ADC PARKS & GREENSPACE ARBORICULTURE

PLANNING APPLICATION: AW/330/14/T

ADDRESS: 23 Wychwood Close and 39 Kingsway Craigweil Bognor Regis
PO21 4DW

BRIEF DESCRIPTION: T1 - Fell dying Cherry Tree on verge and replace with 3 No trees. T2 - Fell dead Sorbus on verge and replace.

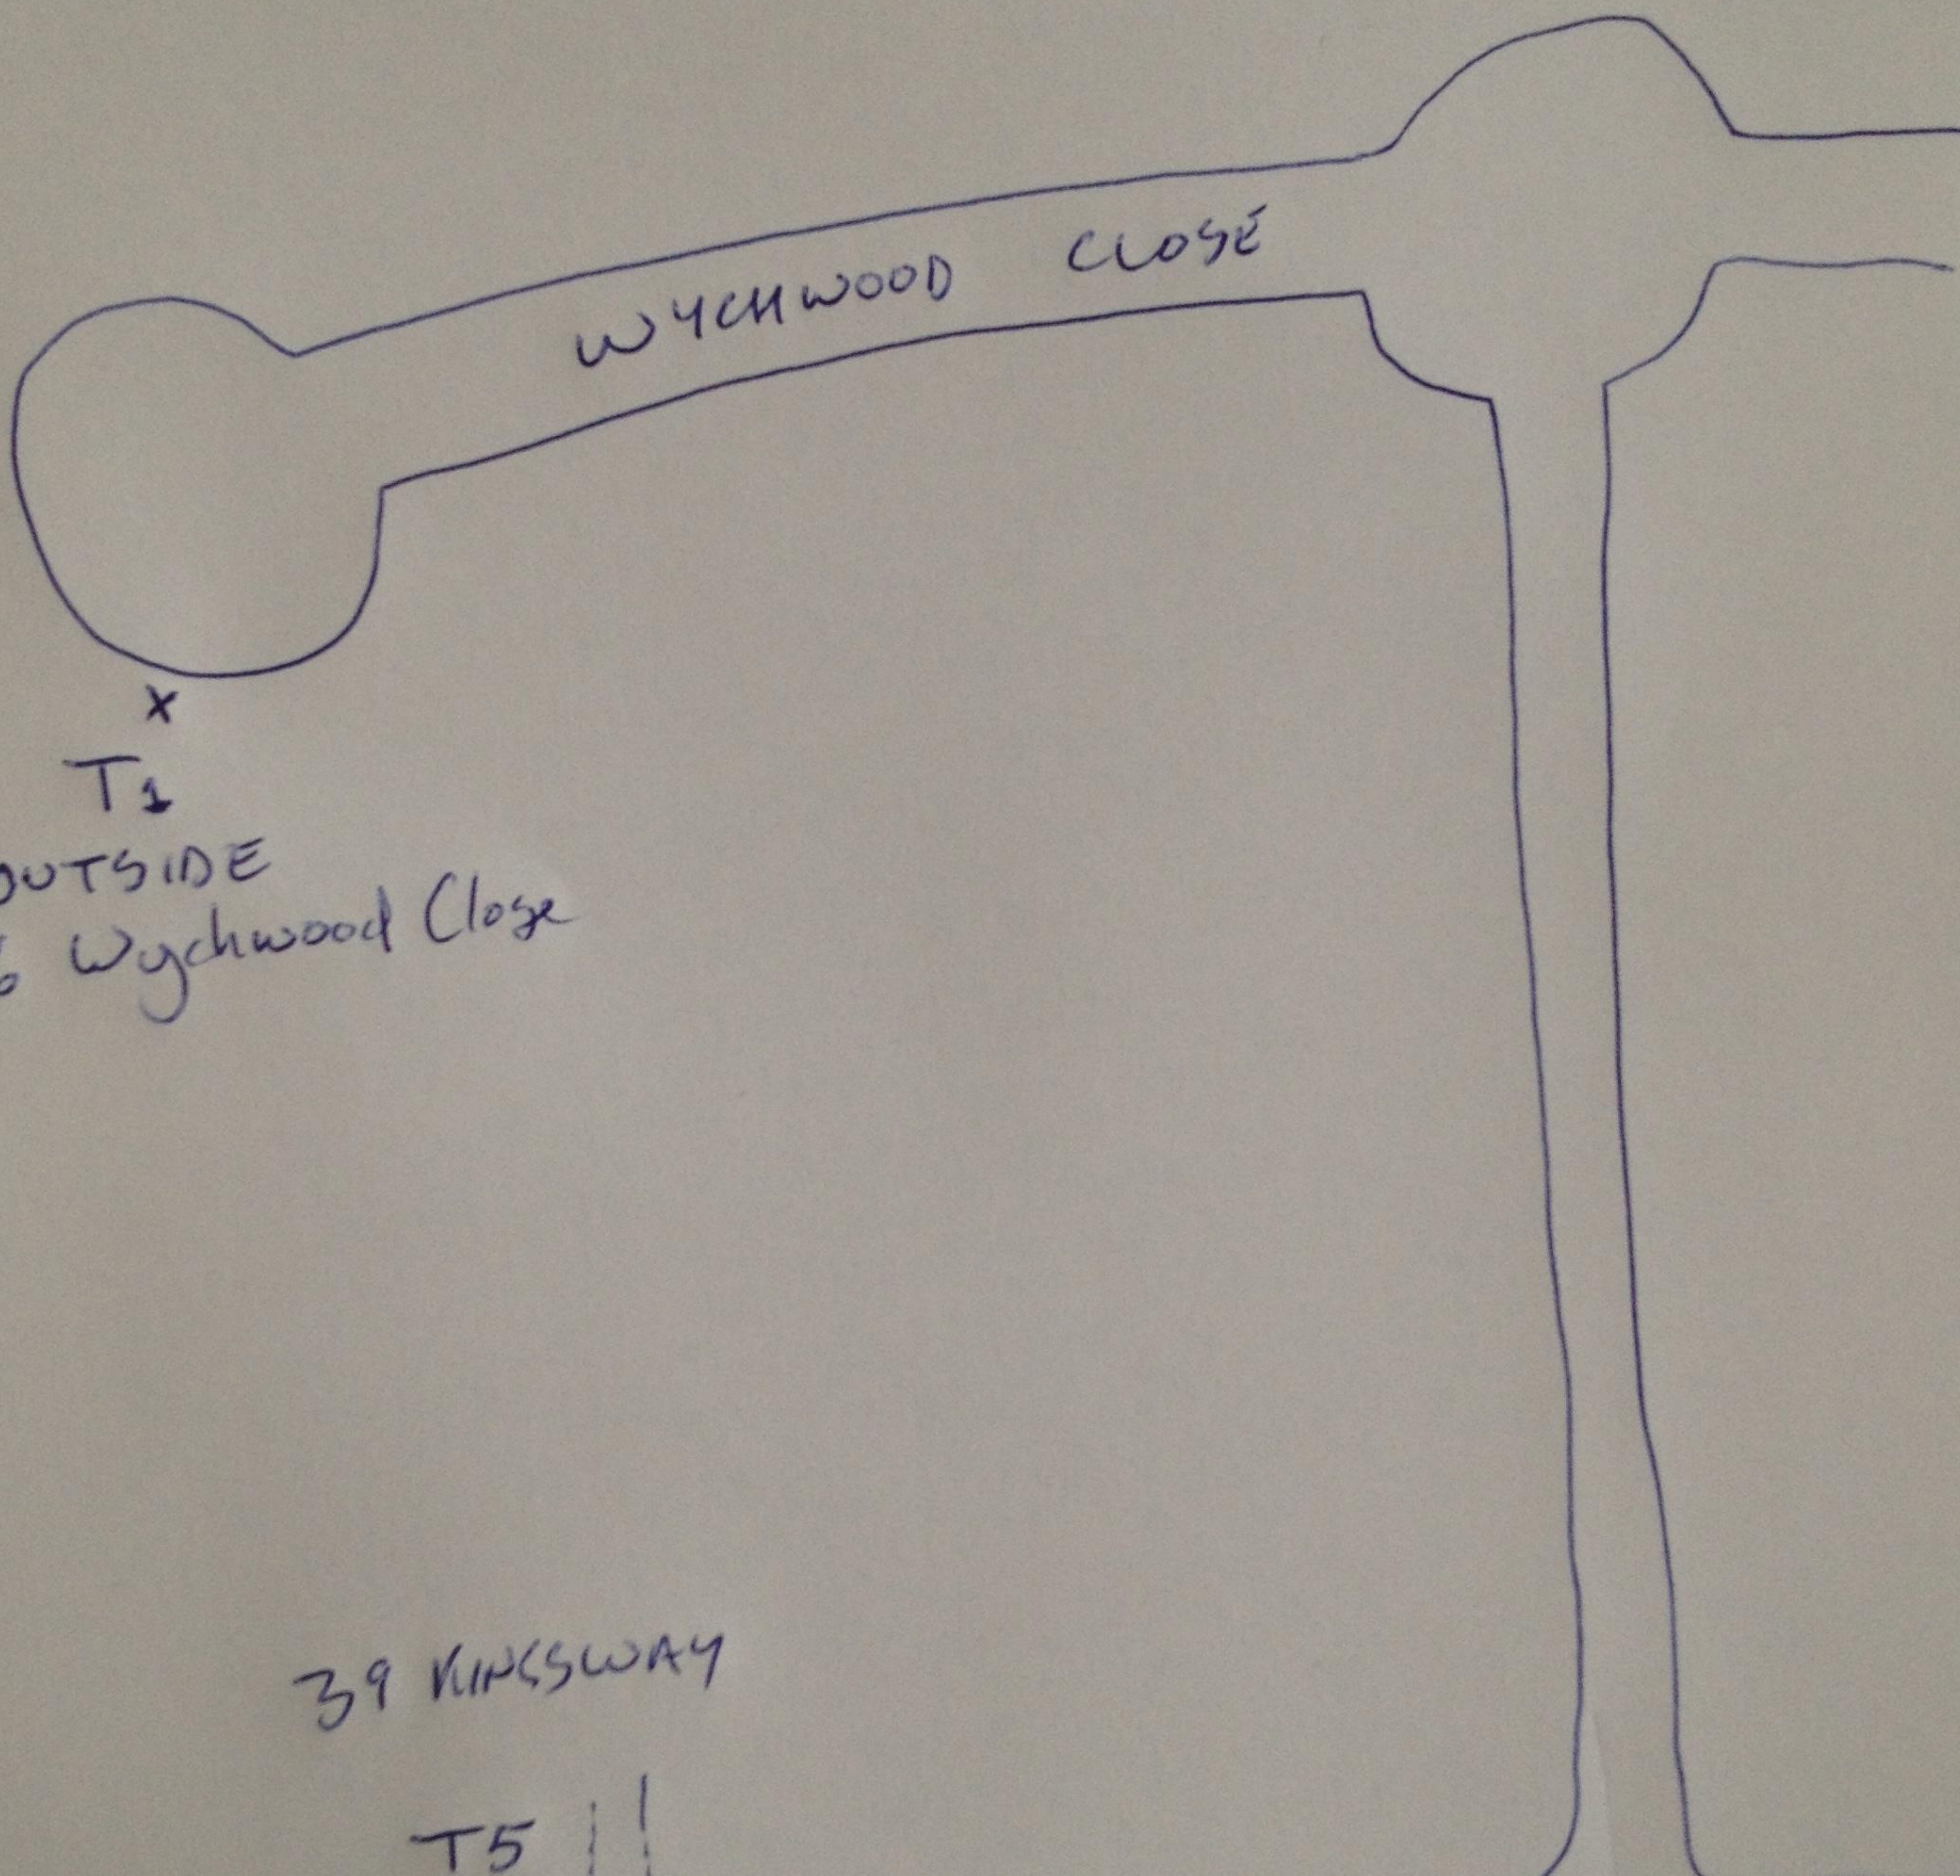
- **T1** is showing excessive abiotic damage mainly in the basal area (this does appear to have been caused by a vehicle hitting the stem), but also some further damage ascending the main stem towards the crown. The damage in the basal area is significant, and has caused major cankering to affect the crown. There is evidence of sizable areas of die-back in the reduced crown. These cankers can be attributed to the abiotic damage sustained on this individual.

- **T5** is an individual that is also showing abiotic damage in the basal area (which does appear to have been caused by a mower/trimmer). There is also a section of the cambium/bark layer 'flaking' off the main stem at the main union at 1.5 meters. This tree is in a bad condition, and is unlikely to make a recovery considering the damage sustained.

- **T1** – I would have no objection to the operation of the felling of **T1**, as it has poor aesthetic value, and has clearly has a retention span that has been drastically reduced.
- **T5** – I would also have no objection to the felling of this tree, as it has also has very poor aesthetic value, and also the 'flaking' cambium and bark would indicate this tree is unlikely to make a recovery.
